**Application Reference:** 2025/0888

**Site Address:** 30 Thurnscoe Lane, Great Houghton, Barnsley, S72 0DY

**Introduction:** This application seeks full planning permission for the Single storey front extension, addition of 2 x front dormers 2 x rear dormers.

Proposed Front Elevation

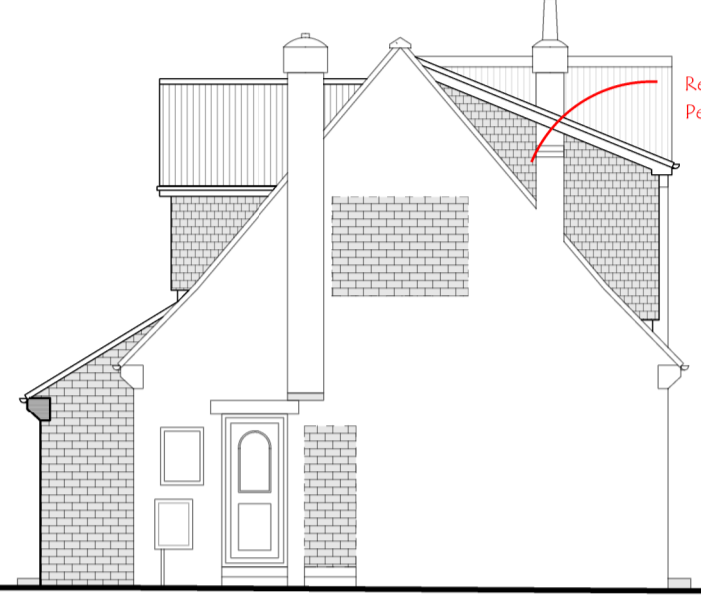
The front elevation of the dwelling currently features an unusual setback which features only one small window. The proposed modest sized front extension would infill this void, in the style of a porch which would extend approximately 1.34m beyond the current furthest aspect of the front elevation and have a width of 4.49m. The proposed roof would be mono pitched with a height of approximately 3.82m and feature an eaves height of 2.55m. The inclusion of a front door and two small windows would support a more traditional appearance for the front elevation whilst not having significant harm to the character of the dwelling or street scene.

Proposed Side Elevation

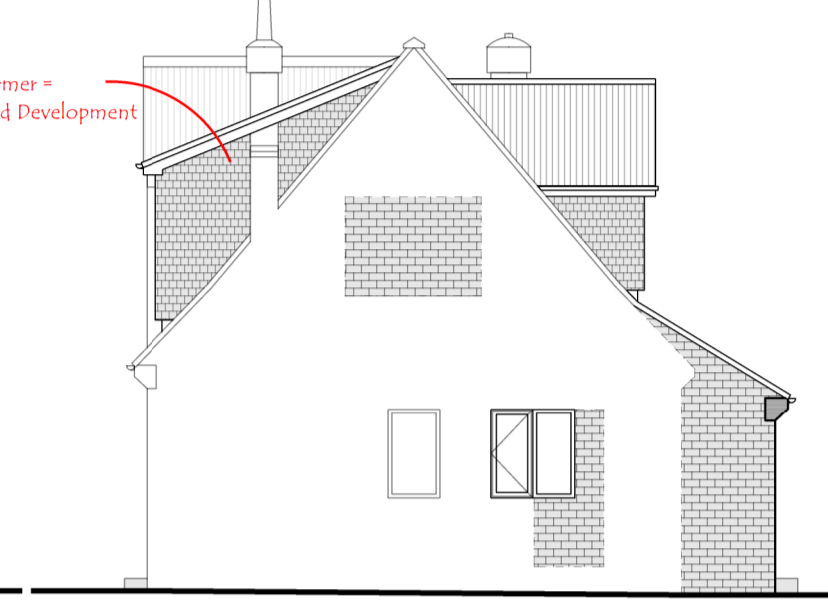
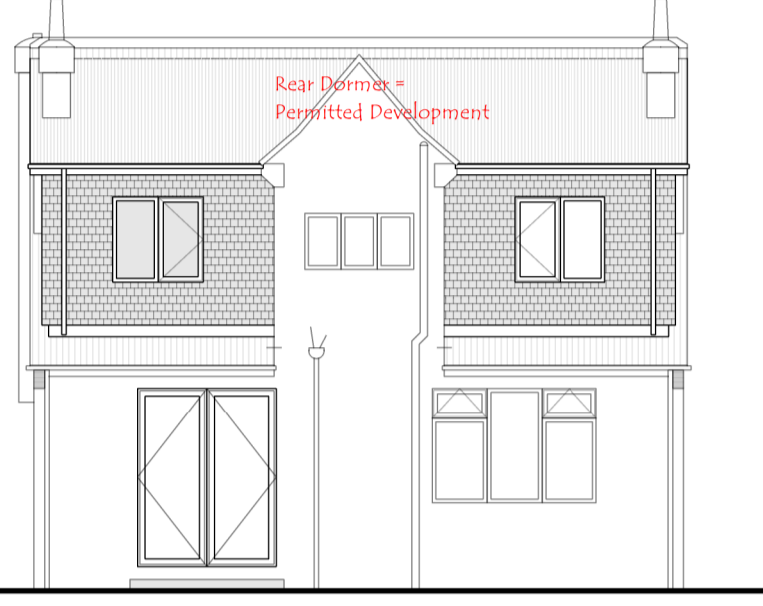
More noticeable alterations to the rear and side elevations would have the potential for a greater impact on the design and character of the dwelling. The direct view of the rear elevation would have limited public view beyond the rear neighbouring dwellings but the for the side elevations, which include large amounts of new brickwork below the roof, and prominent side views of the works to the rear elevation, are more significantly visible.

the view of the side elevation, which consist of lots of new brickwork, was considered quite distracting from the original character of the dwelling, and subsequently the broader street scene. The proposed rear dormers and new roof pitch were also of particular concern.

Following discussions with the applicant's representative, whilst the stance upon the proposal having a significant impact on the character of the dwelling, and a moderate impact on the broader street remain; the proposed works, as reflected in the updated plans, would be considered as permitted development. Therefore, whilst the proposed works to the rear roof, which maintains the original eaves height, and addition of dormer windows could not be approved by the planning department, they do not actually require planning approval but may remain subject to building control approval.

- A street scene plan was requested to illustrate the impact of the proposal within the street scene.
- Concern over the impact upon visual amenity, caused by the proposed works to the rear elevation were rejected, and instead the works were changed to be completed through Permitted development.
